7 August 2017

Carolyn McNally  
Secretary  
Department of Planning & Environment  
GPO Box 39, SYDNEY NSW 2001

Further to the meeting with yourself, representatives of the City of Sydney Council (Council) and Mirvac on 30 June 2017, we write to respond to the issues raised at the meeting.

Approved Application No. SSD 7 317

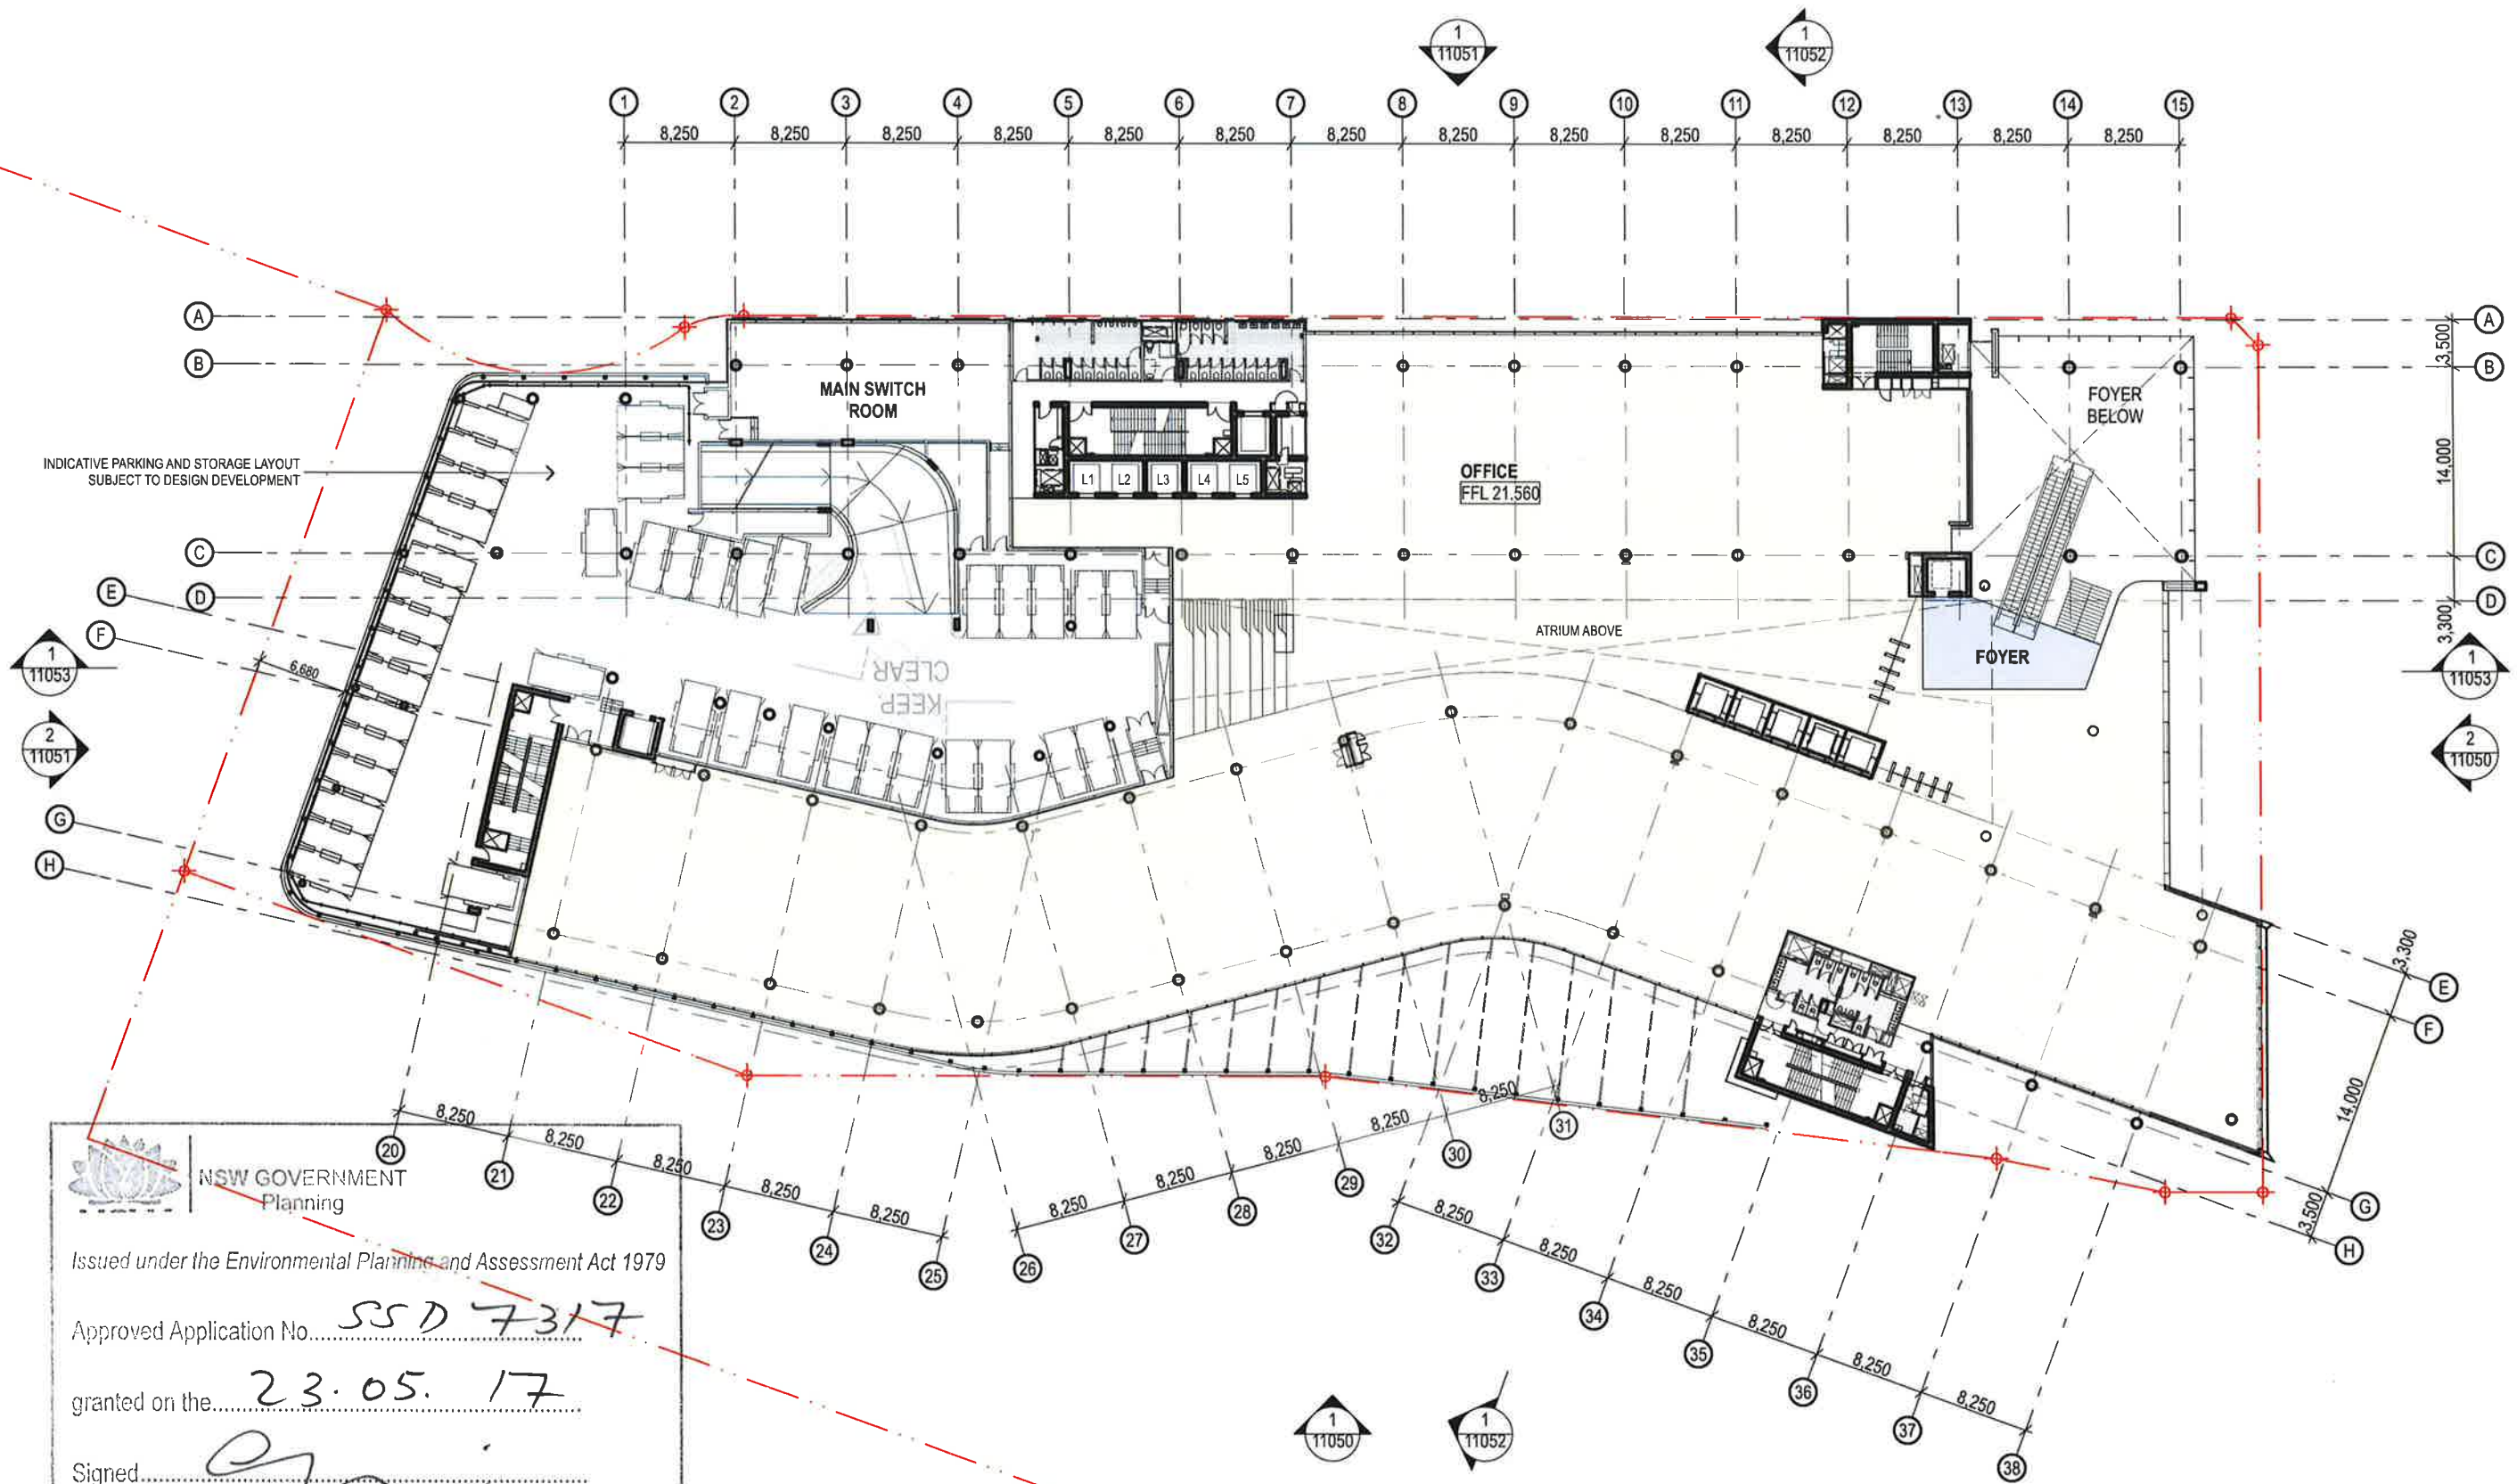
On 23 May 2017, the Department of Planning & Environment (the Department) issued approval of the amended plans for Building 1. The plans for Building 1 (stamped 23 May 2017) illustrate a total of 205 car parking spaces across the Lower Ground, Mezzanine and Upper Ground levels (refer to **Attachment A**).
